Your Ref: 23/01316/F

Erection of 5 two storey age restricted dwellings (55 years) for older people with access, landscaping and associated infrastructure - Land South of Faraday House, Woodway Road, Sibford Ferris (Application No. 23/01316/F)

I am part of a large group (over 165 members) of local residents living in Sibford Ferris and Sibford Gower - the Sibford Action Group ('Action Group') - and write to strongly object to the latest and current planning application (23/01316/F) for 5 no. age-restricted dwellings on land south of Faraday House, Woodway Road, Sibford Ferris ('the site') for the reasons set out in this letter.

Sibford Ferris
 OX15 5QW
 Plot 02
 Elevations

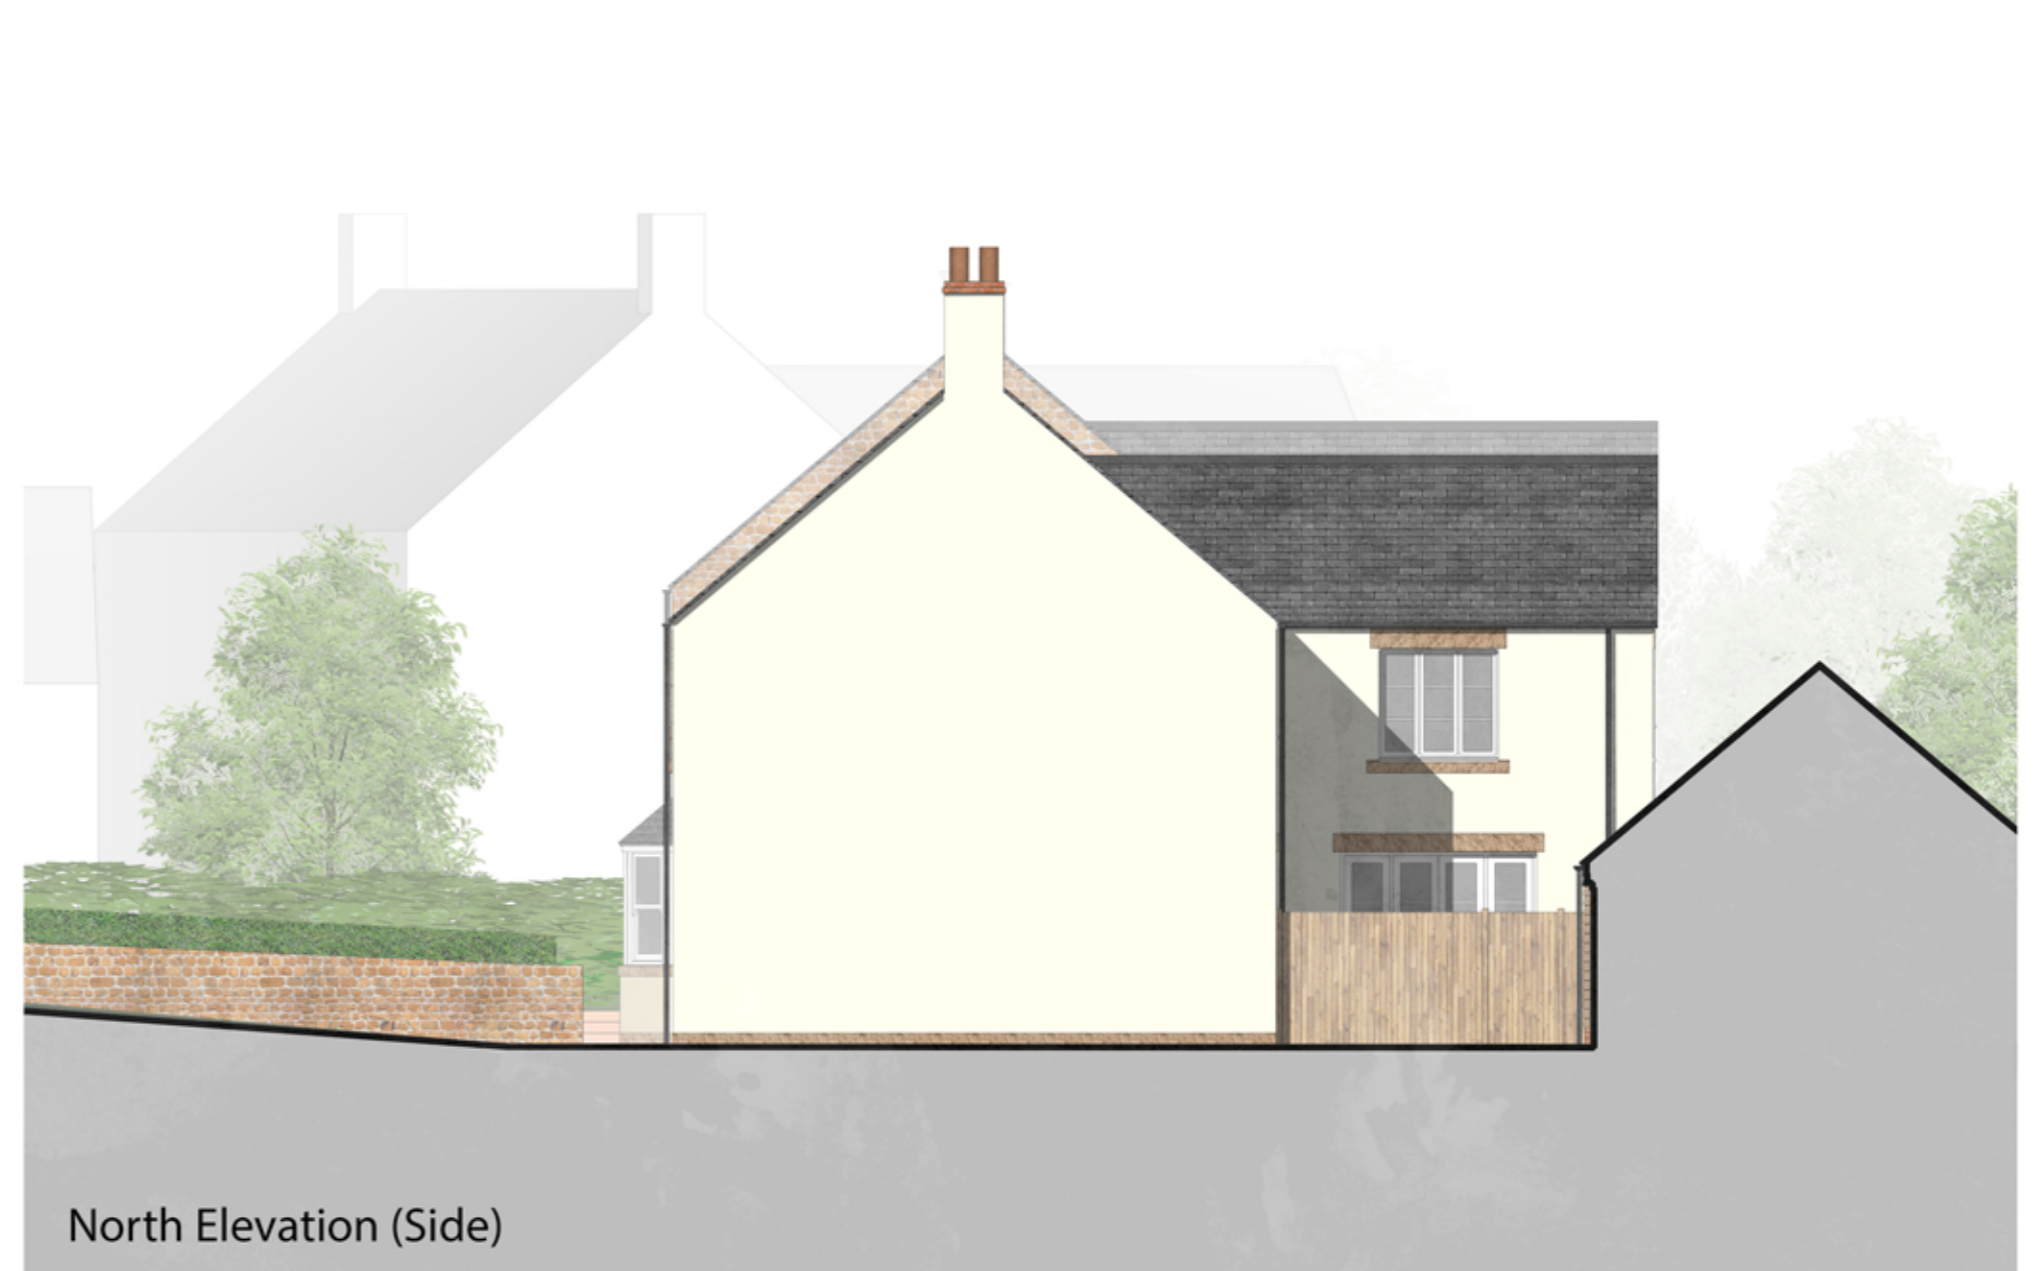
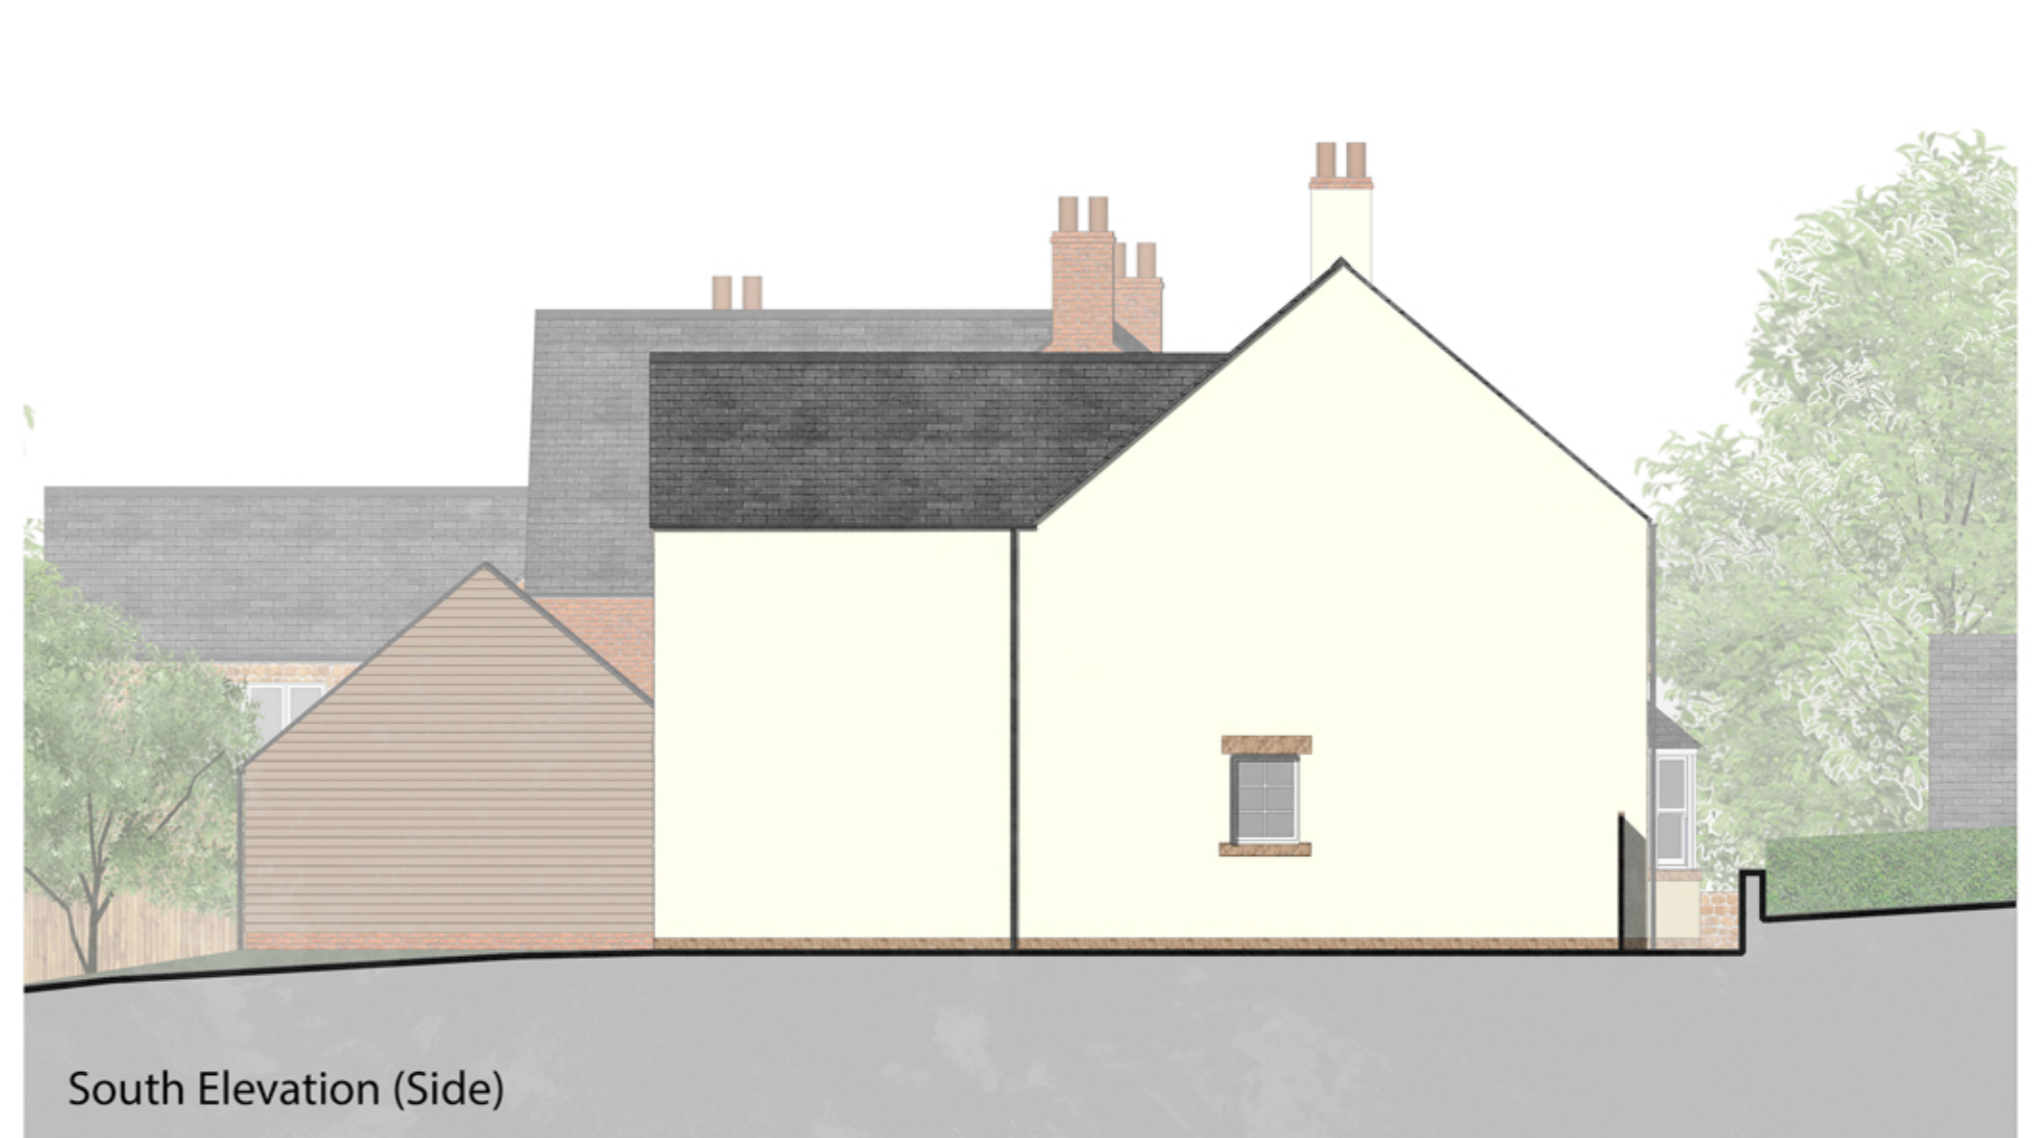
The physical impact of the dwellings – especially Plot 5 – is perhaps most acute upon Faraday House just 15 metres to the north of the site, as shown on Figure 6 taken from the application.
